DECISION DELEGATED TO DEVELOPMENT MANAGER

Application No: H13-0930-19 **Applicant:** Mr J Barnett

Proposal: New Dwelling - approved under H13-1021-17. Modification of Condition 2 to allow amendments to previously approved plans

Location: Site At Rear Of 10 High Street Moulton Spalding

PROPOSED ELEVATIONS

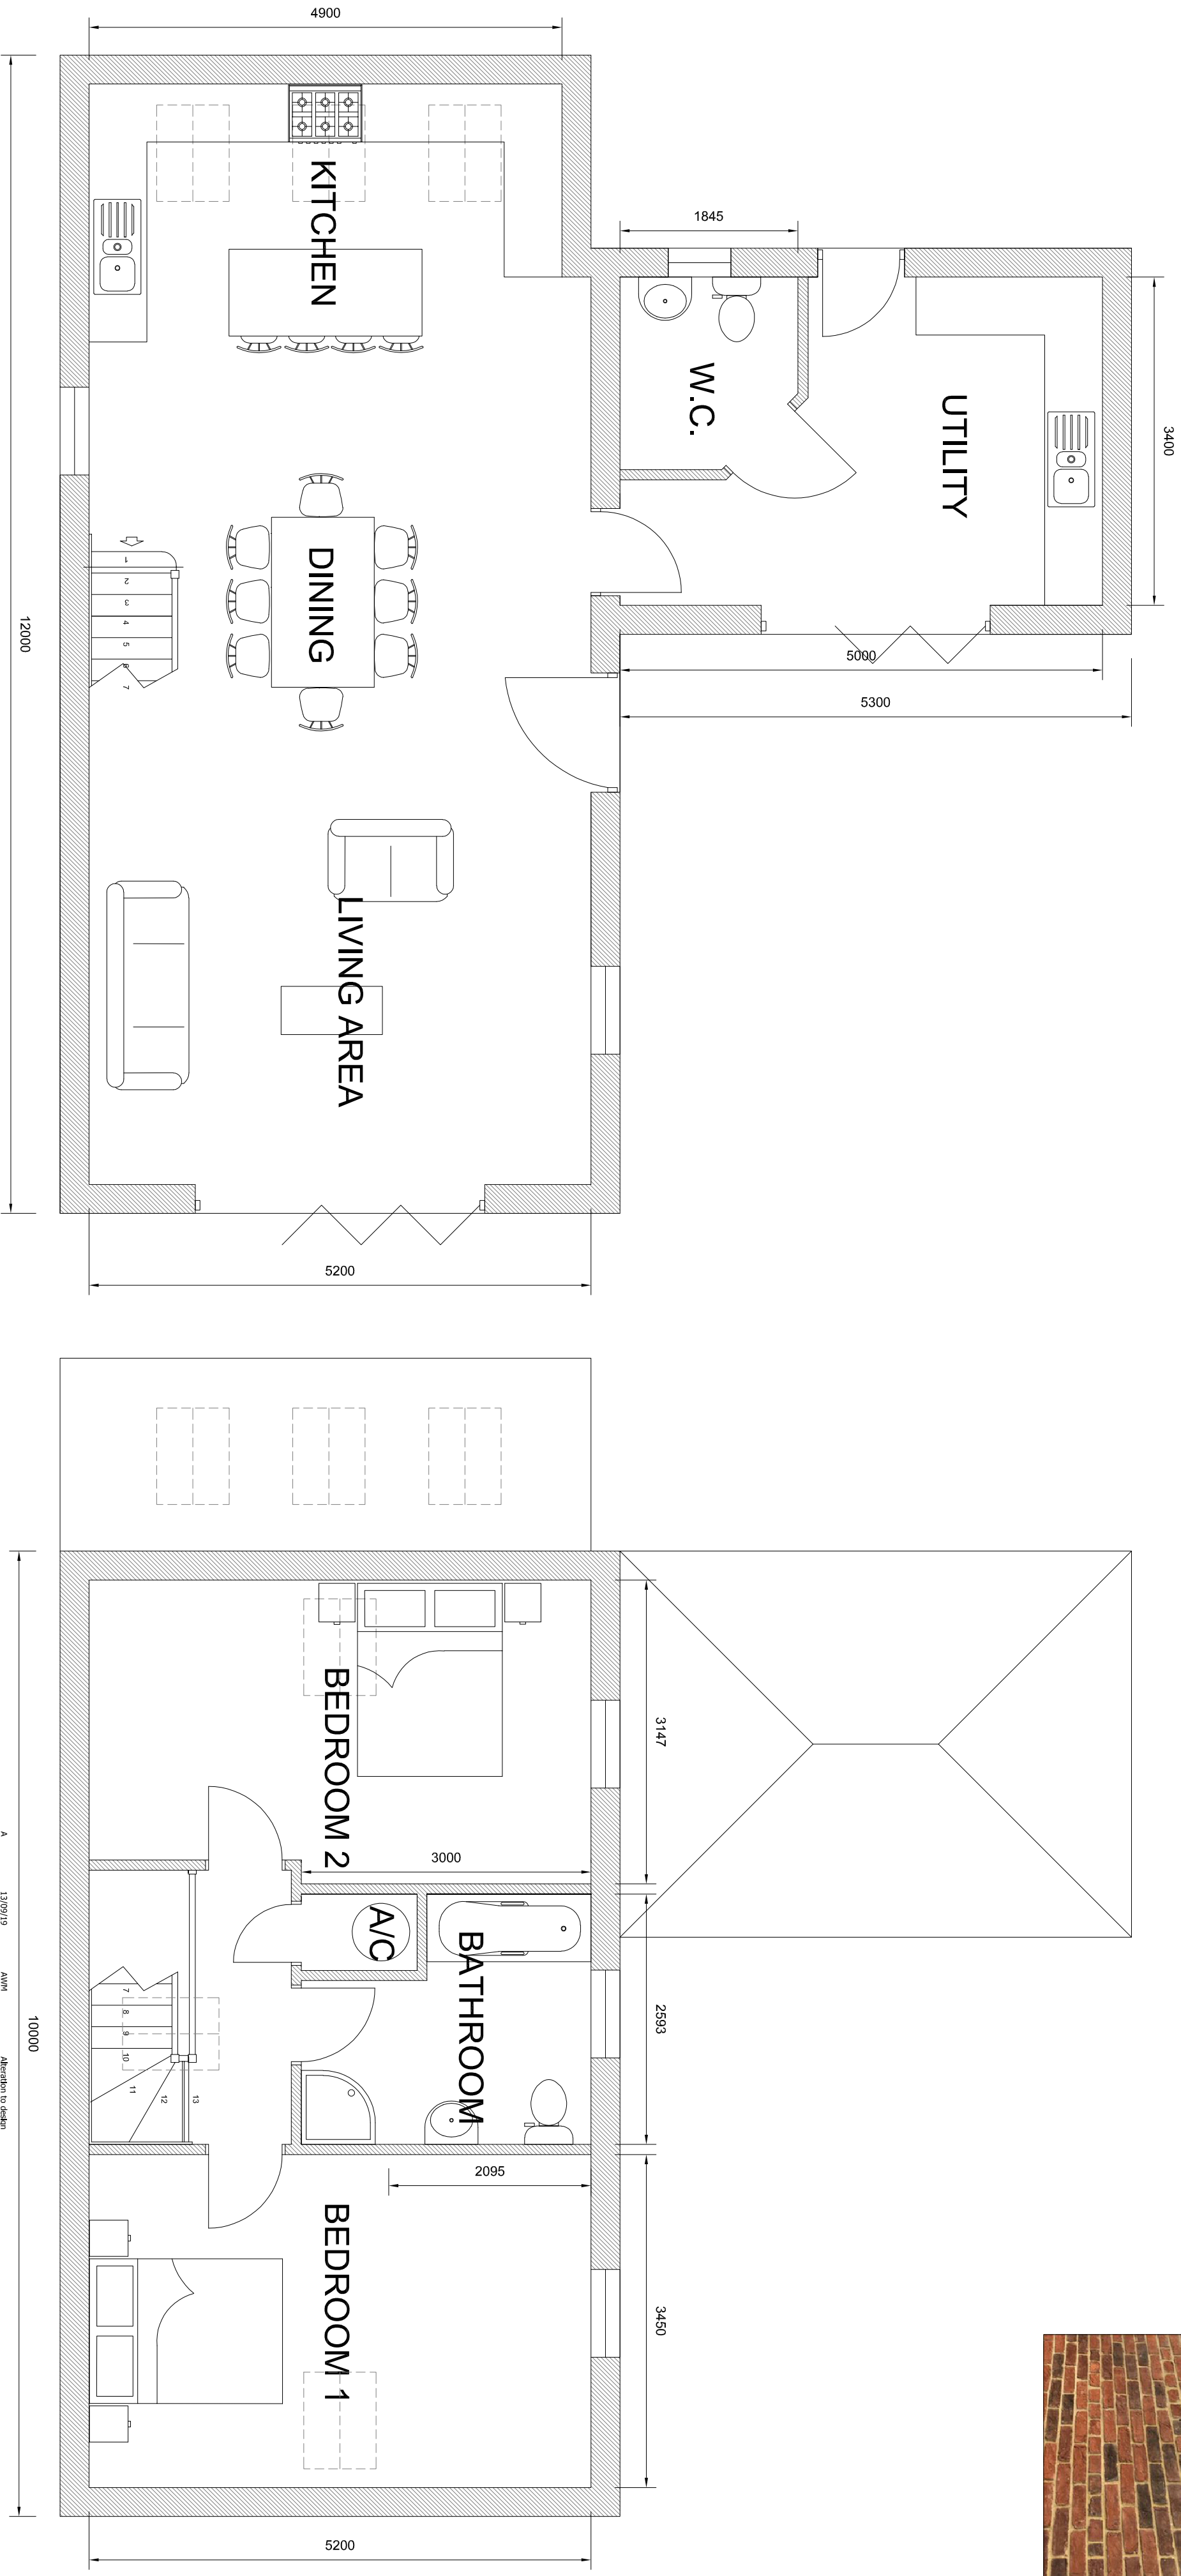
The proposed alterations to the original plans are as follows; Firstly, it is proposed that the contemporary, glass-sided front door proposed in the original plans be changed to a more traditional in appearance stable-style door.

The mock-'Hayloft' style shutter window proposed in the original plans on the rear elevation to be removed.

The 2 large floor to ceiling windows on the side elevation of the proposed utility room to be replaced with a bi-fold door, whilst retaining the overhead oak beam.

It is not considered that the proposed amendment to condition 2 of H13-1021-19 will present any risk to the character of the conservation area or the significance of any nearby listed buildings. The newly proposed front door is arguable more appropriate to the character of the area and the same applies to the newly proposed bi-fold doors on the utility room, as the bi-fold doors will hold a more 'traditional' appearance than the approved large glazing panels. The loss of the mock 'hayloft' window on the 1st floor of the rear elevation is regrettable as it did appear to 'break up' what is admittedly a rather blank elevation, however, I do not believe its loss will be of any great harm to the overall design of the building or the visual qualities of the conservation area, especially as the rear elevation will not at all be visible from the public realm.

The proposed modification of condition 2 will not cause any negative amendment to the residential amenity of any nearby properties. In fact, the removal of the rear, 1st floor window will now completely remove any risk of overlooking the gardens of the residential property immediately to the West.
